CITY OF ALBUQUERQUE

Re: Eagle Technology
3821 Singer NE Albuquerque NM
Traffic Circulation Layout
Engineer's/Architect's Stamp 01-06-20 (F17D058)

Based upon the information provided in your submittal received 02-04-20, the above referenced plan cannot be approved for Building Permit until the following comments are addressed:

A1 ARCHITECTURAL SITE PLAN / TRAFFIC CIRCULATION LAYOUT / FIRE 1

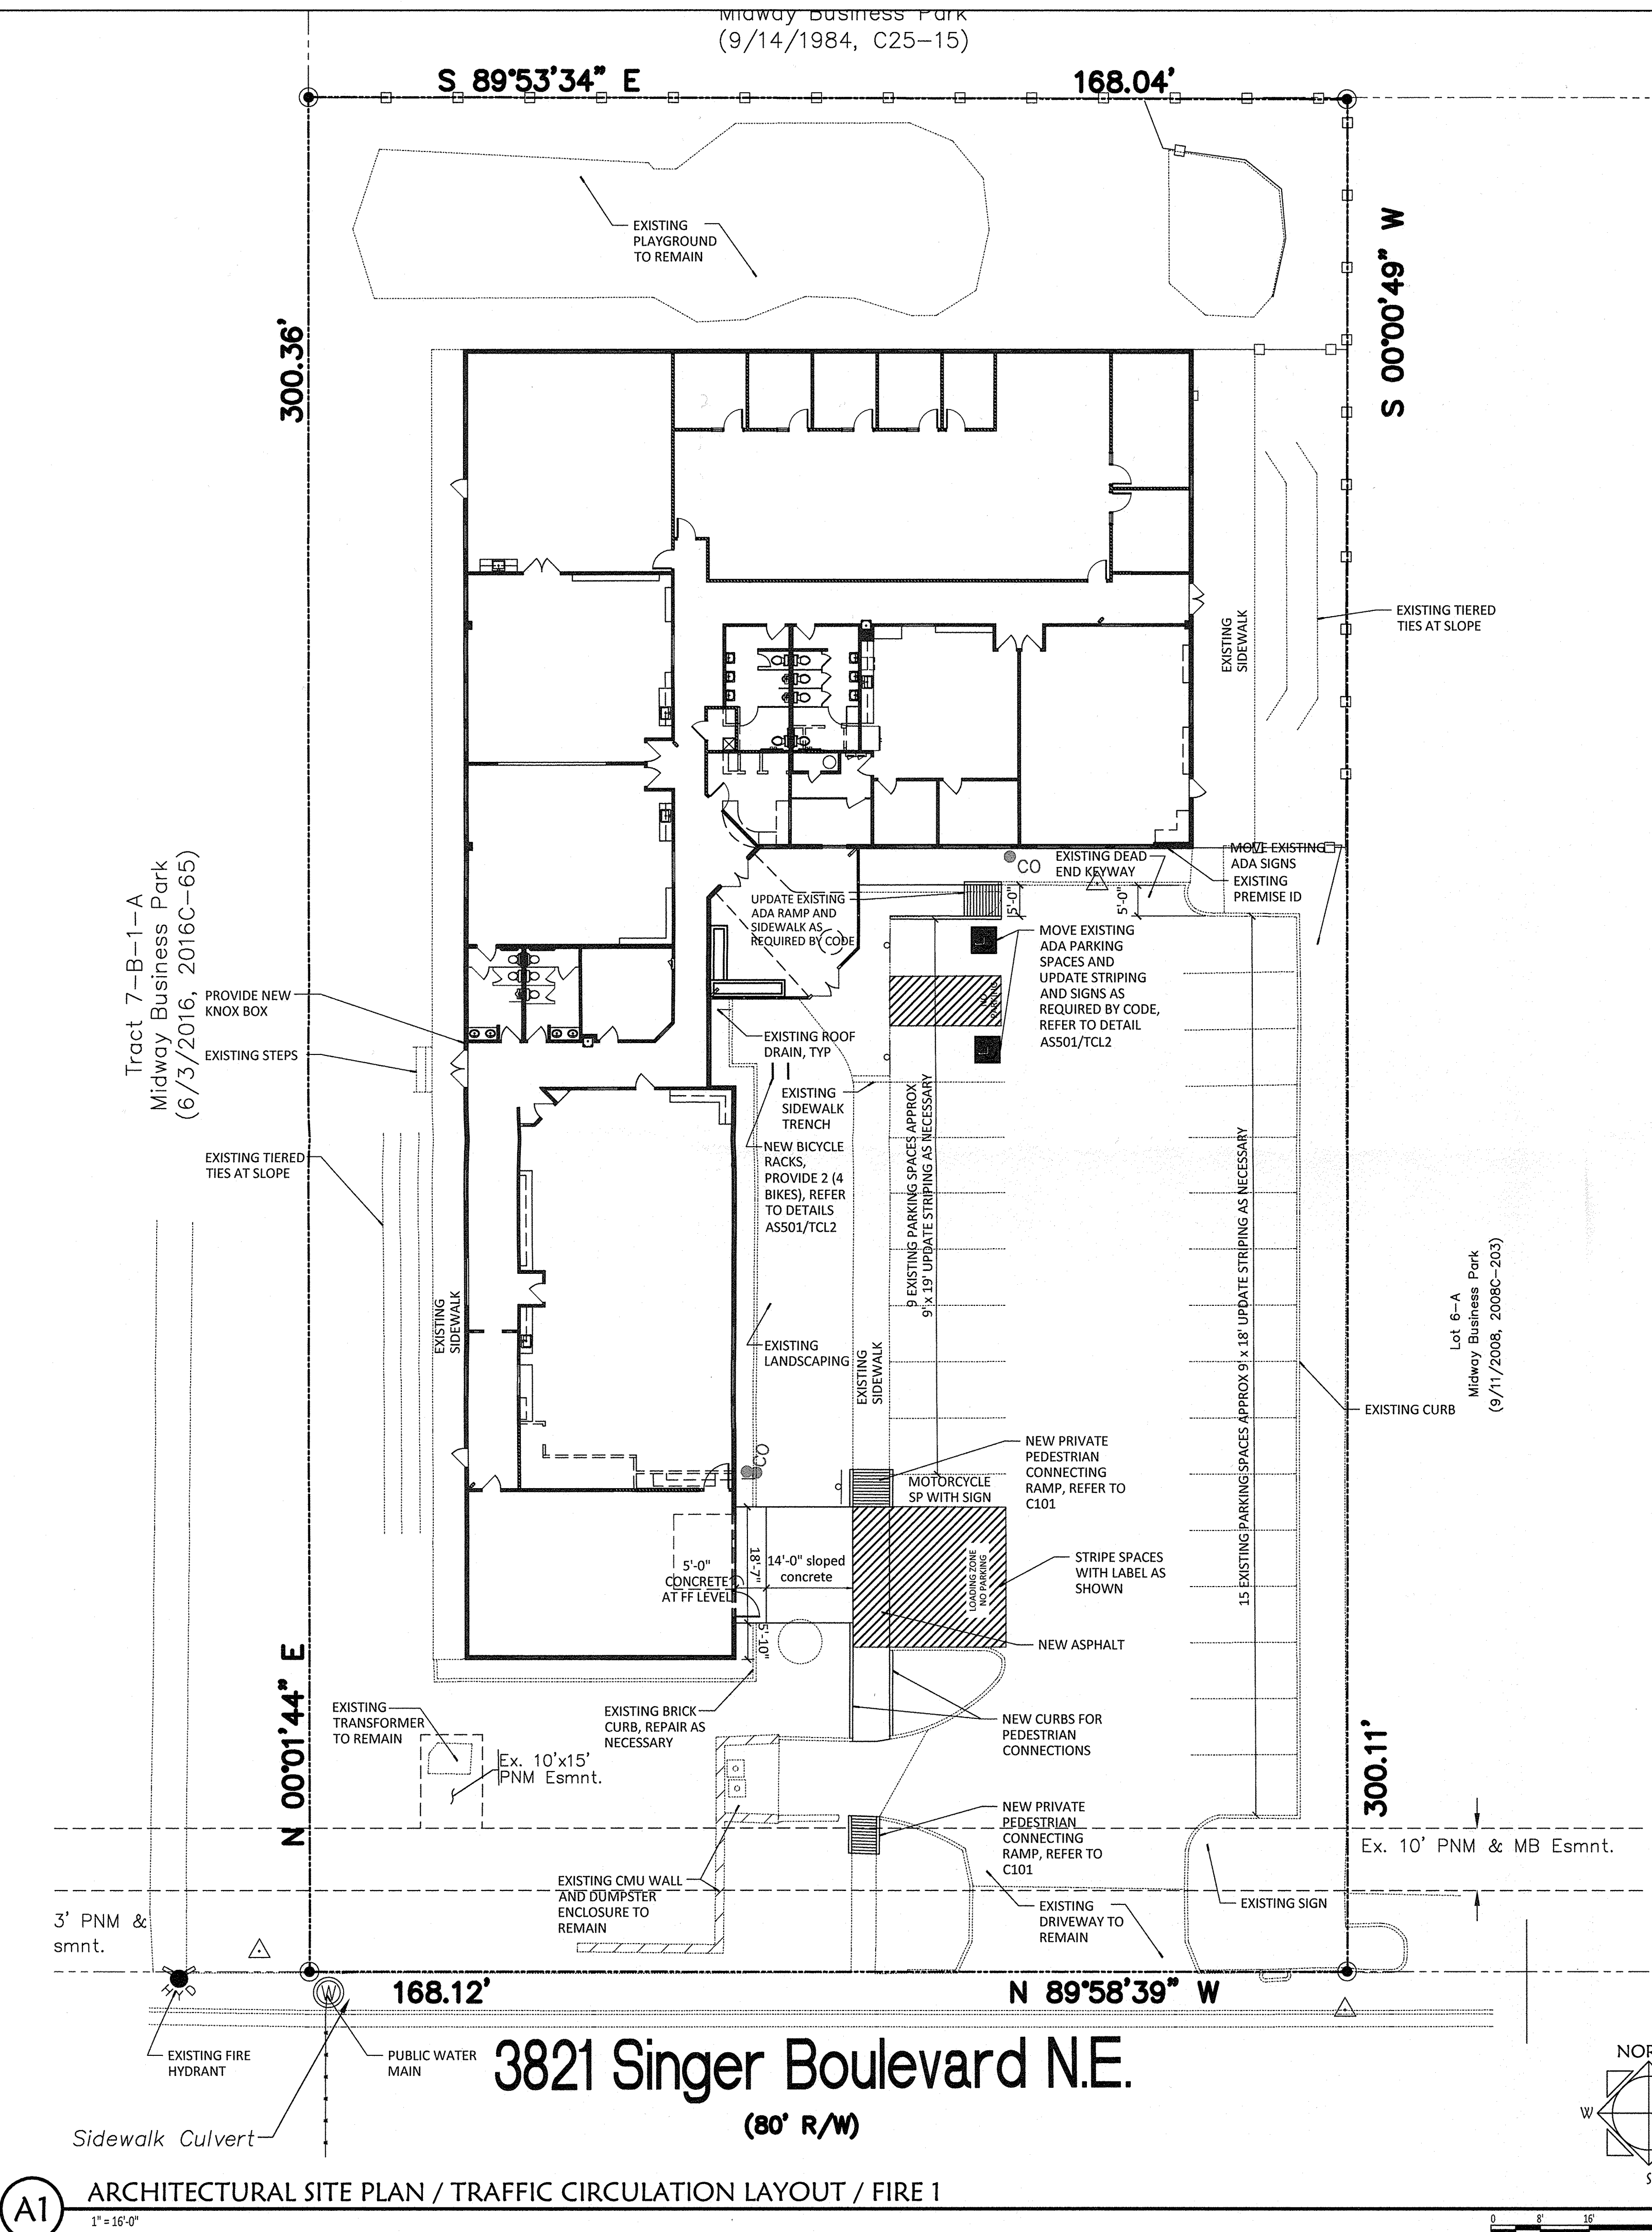
1. The ADA accessible spaces must include an access aisle. Van accessible aisles should be 8ft wide; all others should be 5ft wide.
2. The ADA accessible parking sign must have the required language per 66-7-352.4C NMSA 1978 **"Violators Are Subject to a Fine and/or Towing."** Please call out detail and location of signs. **Please show the details.**

3. The ADA access aisles shall have the words **"NO PARKING"** in capital letters, each of which shall be at least one foot high and at least two inches wide, placed at the rear of the parking space so as to be close to where an adjacent vehicle's rear tire would be placed. (66-1-4.1.B NMSA 1978)

5. Show bike rack details.
6. A 5 ft. keyway is required for dead-end parking aisles.
7. Per DPM, a 6 ft. wide ADA accessible pedestrian pathway is required from the ADA parking stall access aisles to the building entrances. Please clearly show this pathway and provide details.

8. Please remove all clouds.

B4 MOTORCYCLE PARKING SIGN
1/2" = 1'-0"

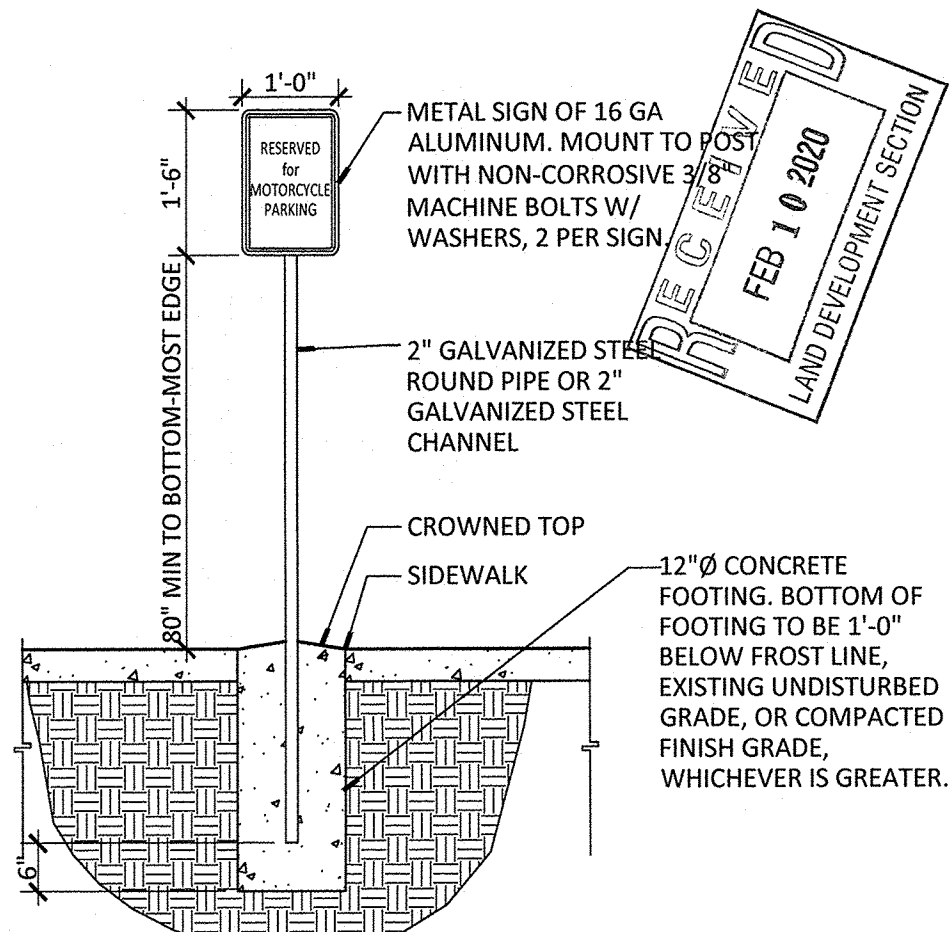
4. Motorcycle parking spaces shall be designated by its own conspicuously posted upright sign, either free-standing or wall mounted per the zoning code.
